Mr Simon Stubbs
Herricks
School Lane
Arundel
BN18 9DR

Listed Building Consent for Alterations, Extension or Demolition of a Listed Building

Development: Repair and painting of the exterior walls, doors and windows to the front and rear elevation.
Location: Herricks School Lane Arundel BN18 9DR

HERRICKS – FRONT ELEVATIONS

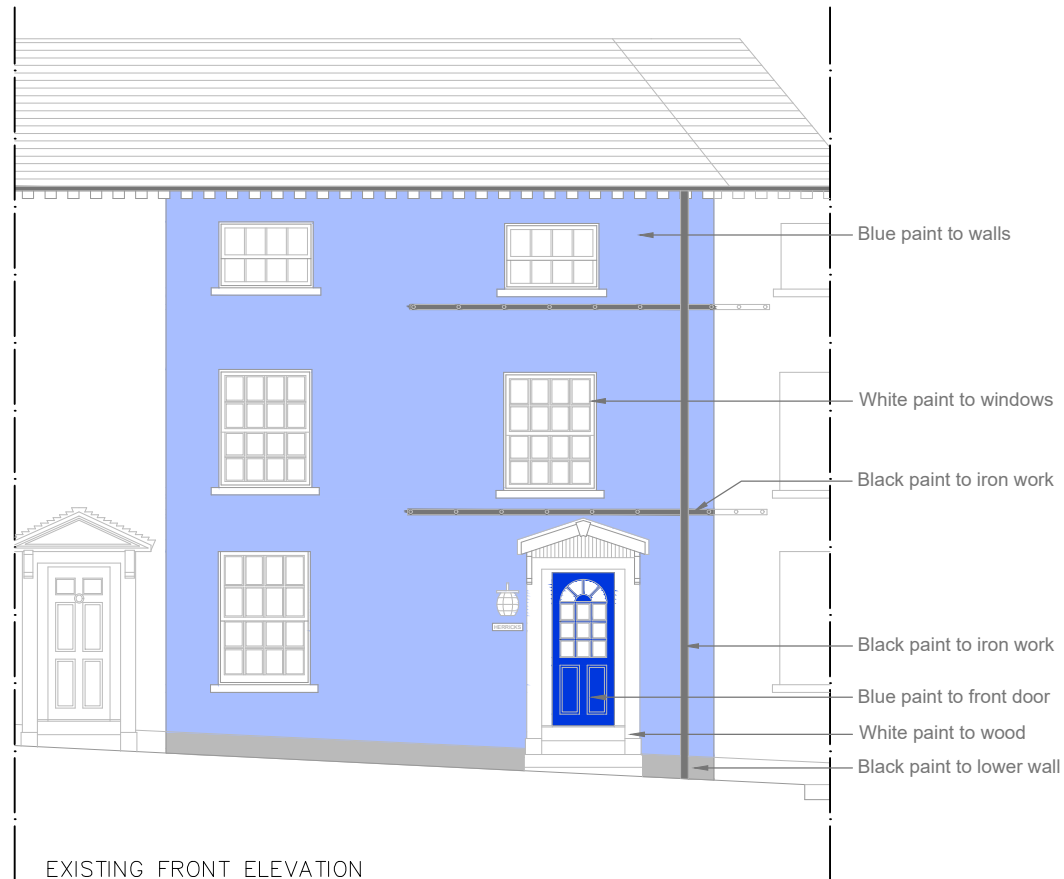
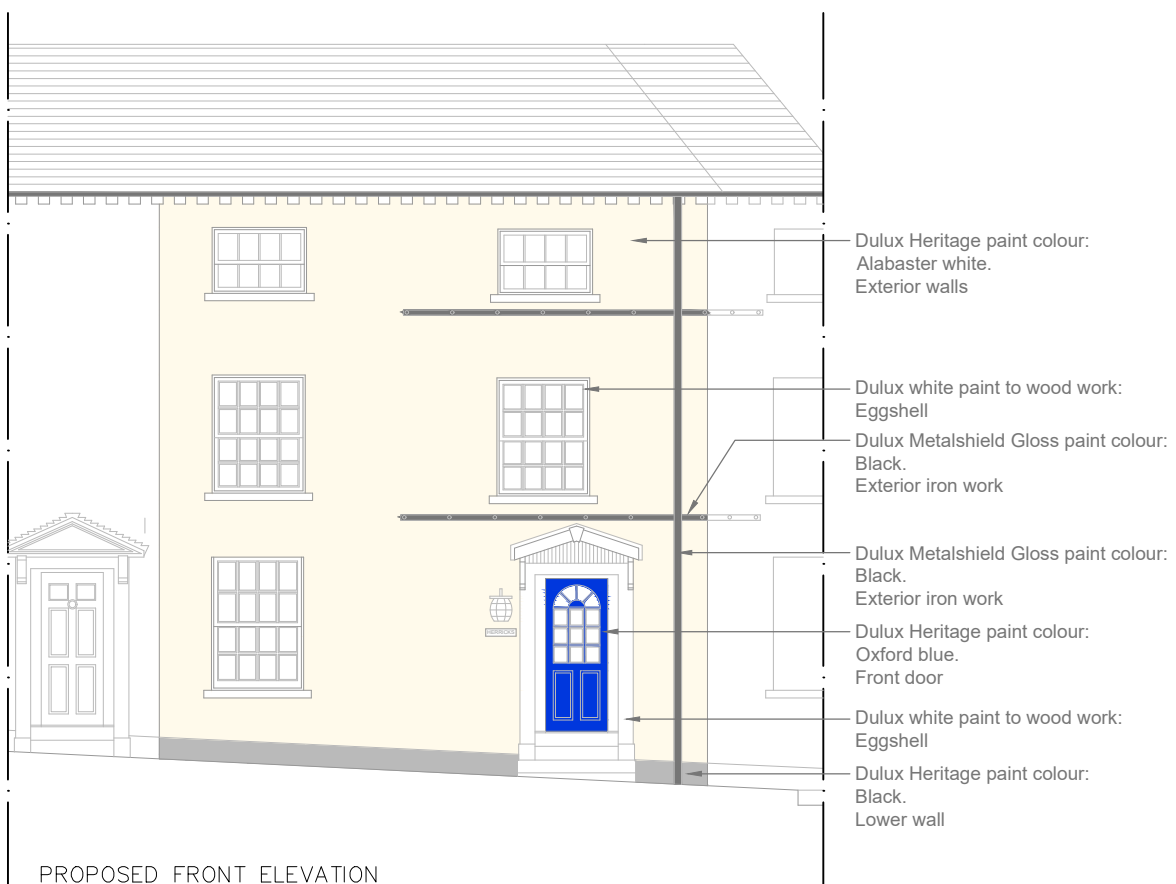
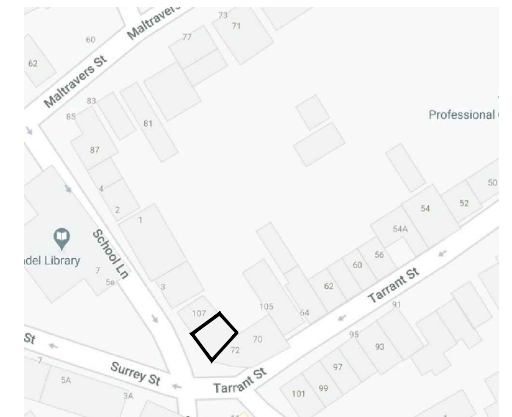
Please submit a copy of clearly labelled elevations with the amendments proposed at a scale of 1:50 or 1:100. Further details can be found in the Validation Requirements List.

Herricks, School Lane, Arundel, West Sussex, BN18 9DR

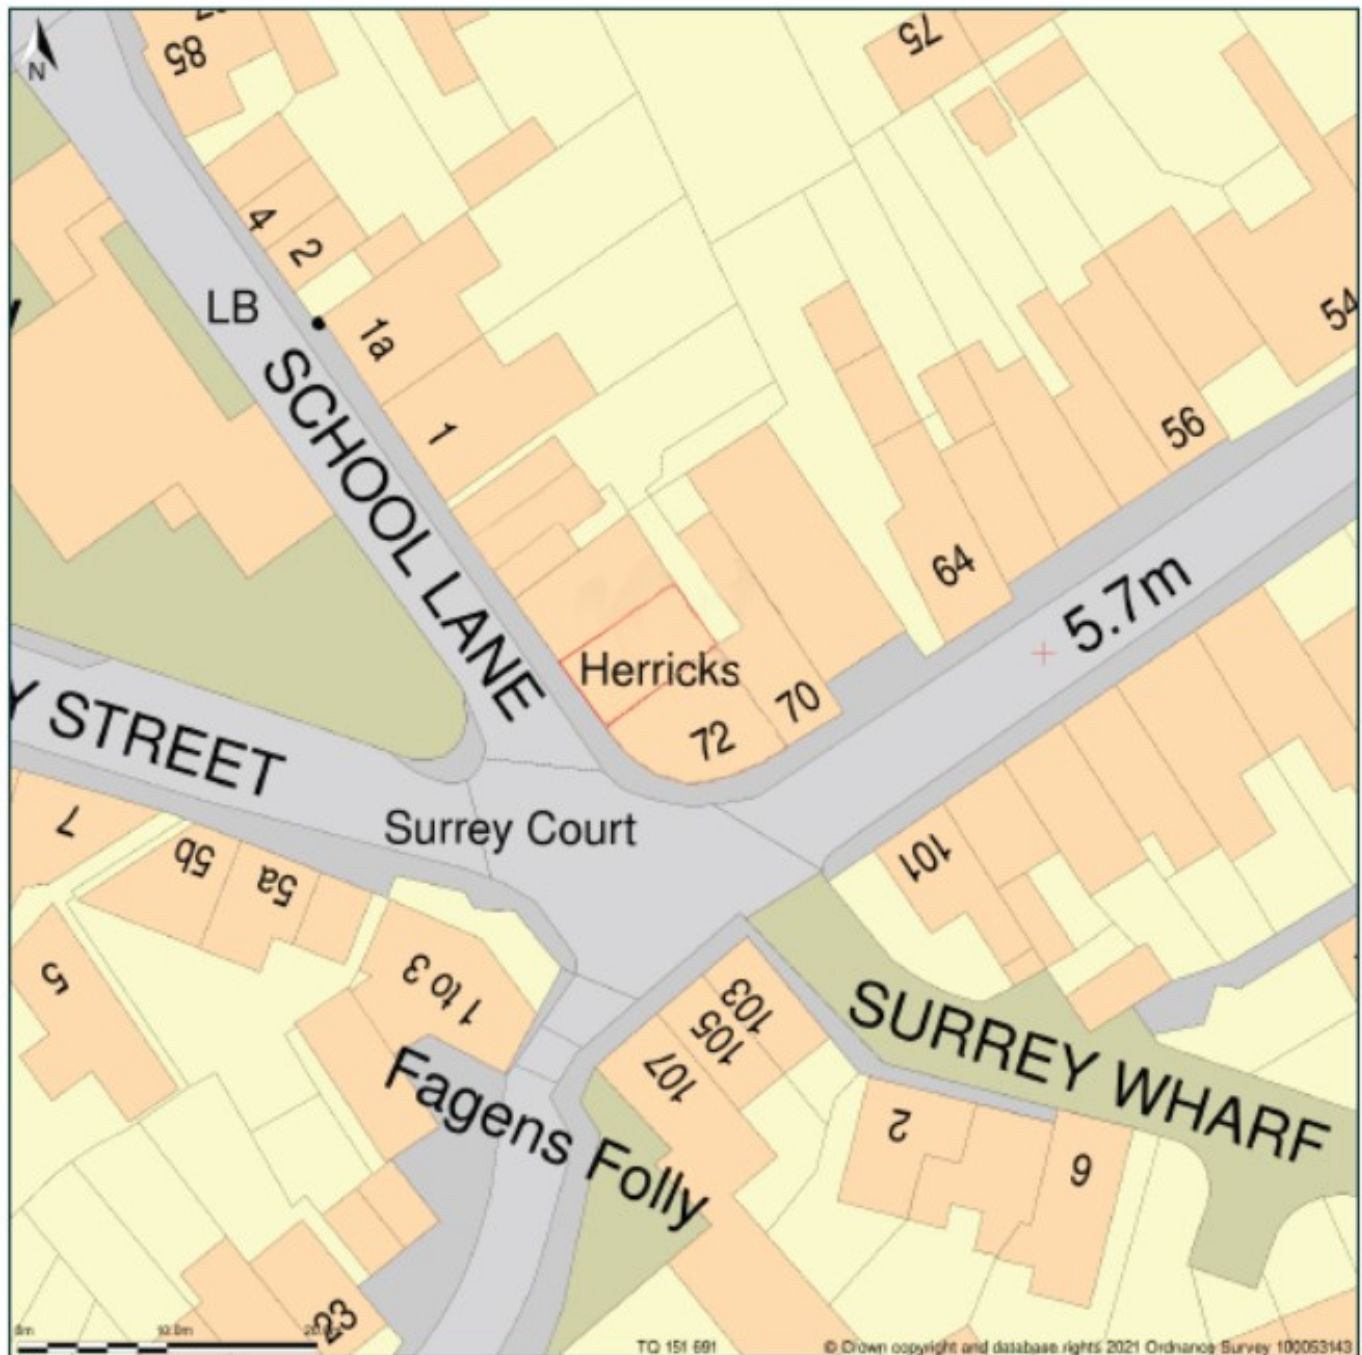
There are 2 sites outlined on the location plan. Only the site address should be outlined in red. Please review and amend accordingly.
